Local Policing Support Team

Our Ref: LM/ARU/20/16A

Date 23rd June 2020

RE: Wings Nursery Lidsey Road Woodgate PO20 3SU

Parking Strategy Diagram

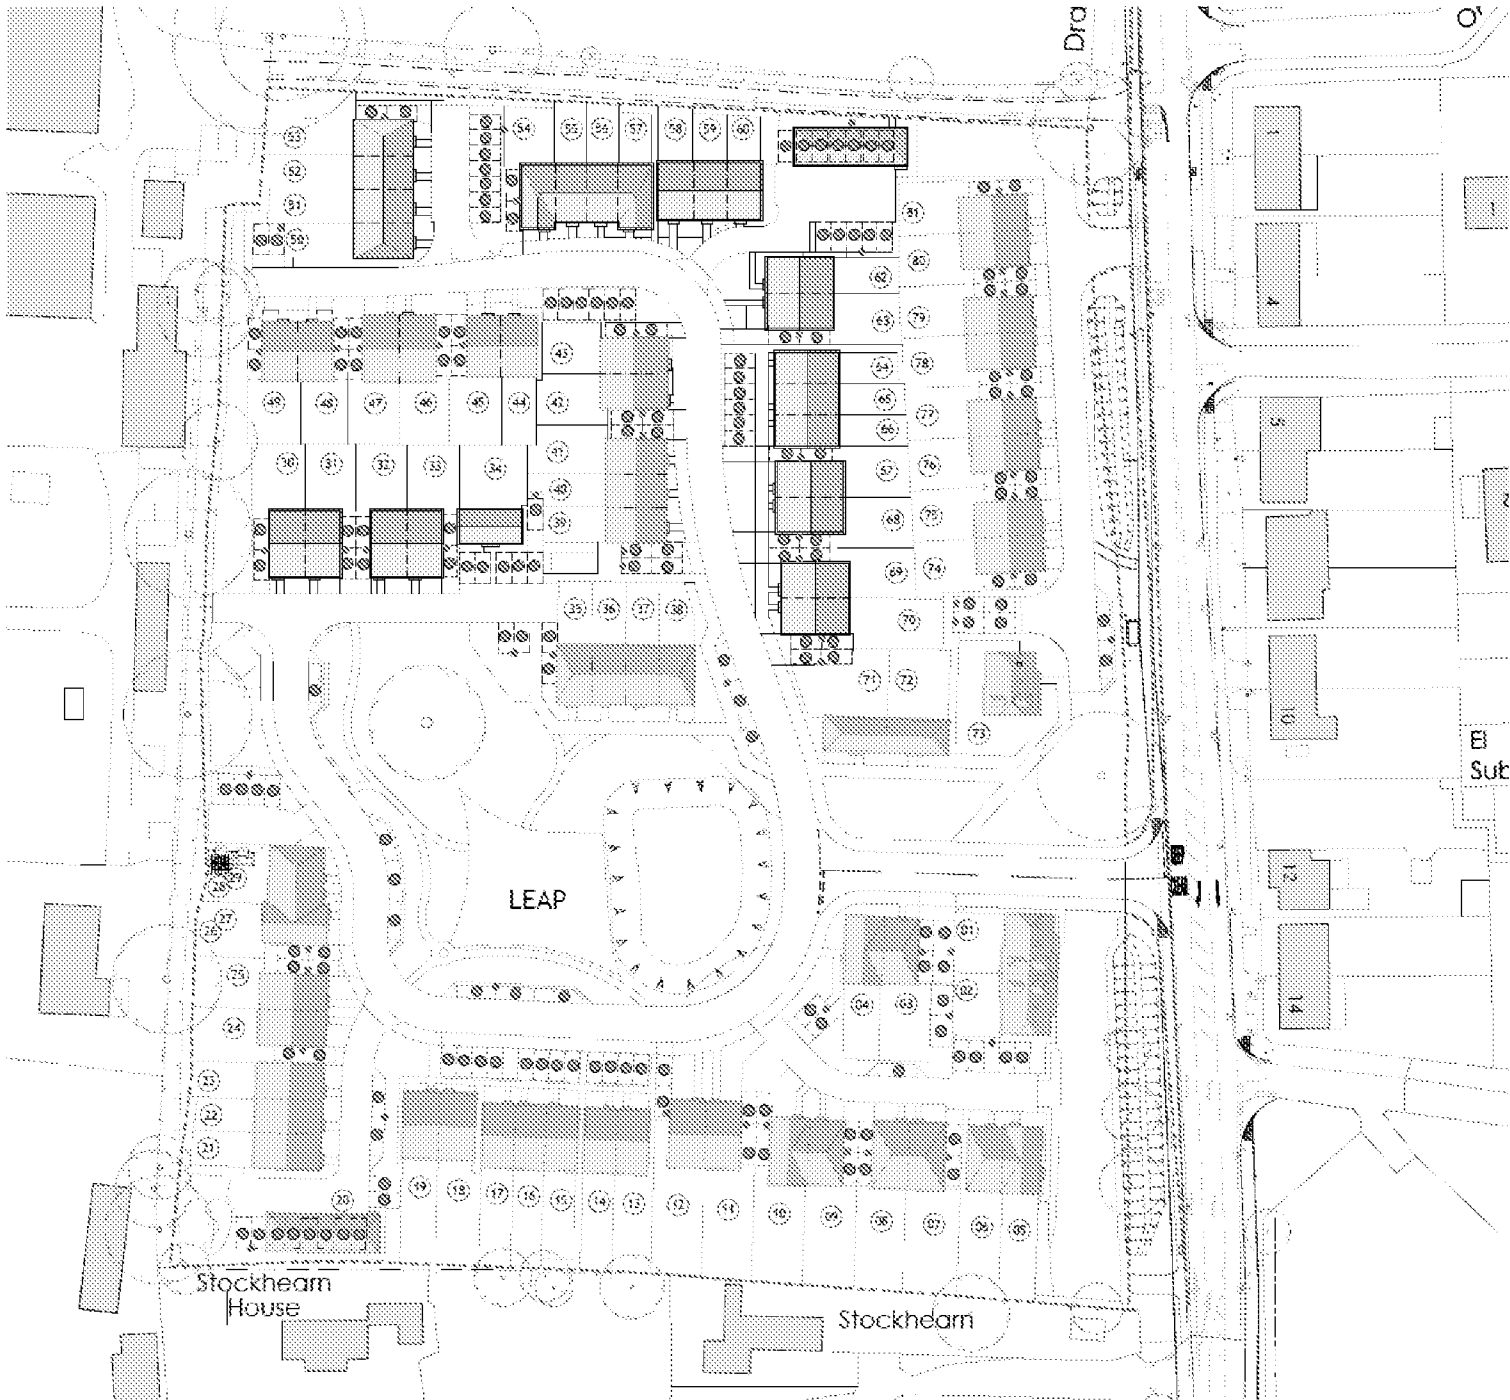
Where communal parking occurs it is important that they must be within view of an active room within the property. An active room is where there is direct and visual connection between the room and the street or the car parking area. Such visual connections can be expected from rooms such as kitchens and living rooms, but not from bedrooms and bathrooms. Gable ended windows can assist in providing observation over an otherwise unobserved area.

Boundaries Diagram

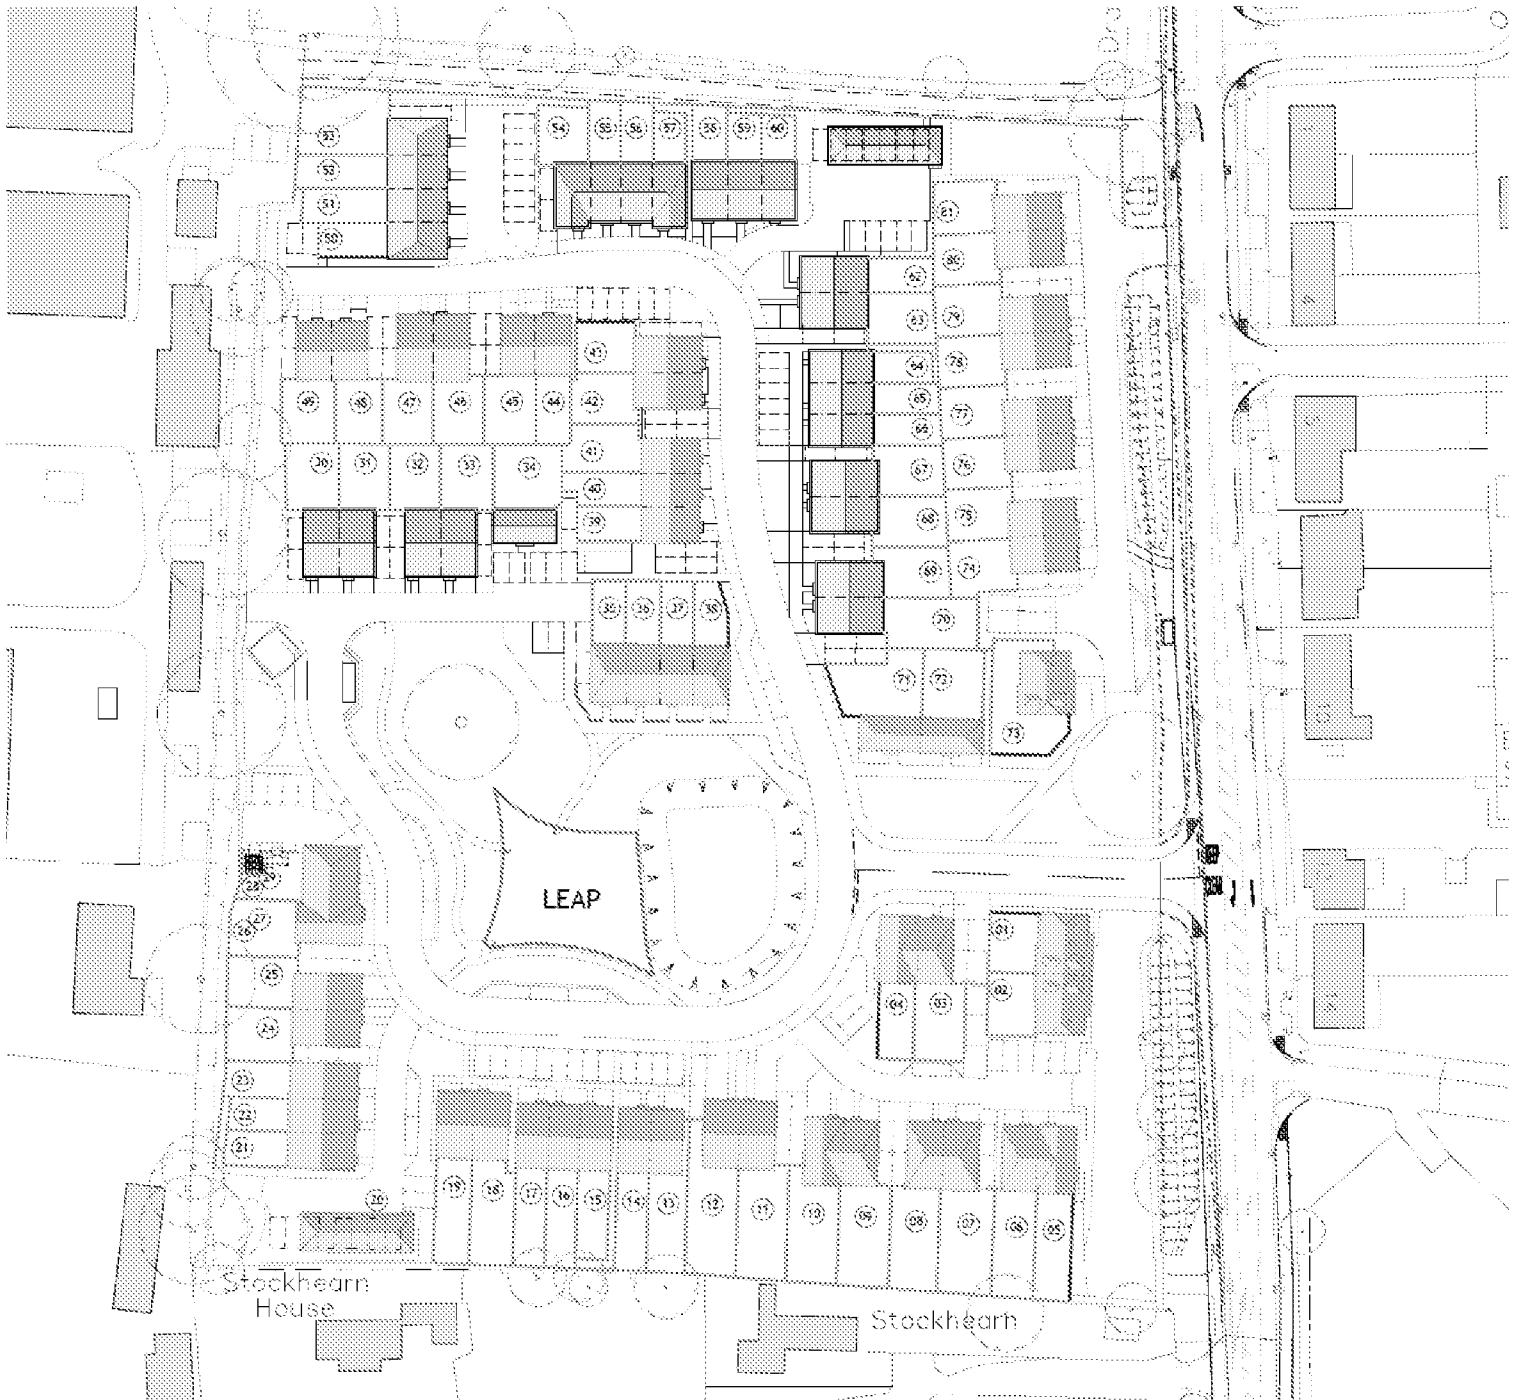
With regards to the LEAP, areas of play should be situated in an environment that is stimulating and safe for all children, be overlooked with good natural surveillance to ensure the safety of users and the protection of equipment, which can be vulnerable to misuse. They should be designed to allow natural surveillance from nearby dwellings with safe and accessible routes for users to come and go. Boundaries between public and private space should be clearly defined and open spaces must have features which prevent unauthorised vehicular access. I would ask that when consideration is given to the eventual location for the LEAP that it is surrounded with railings with self-closing gates instead of the proposed timber fence to provide a dog free environment.
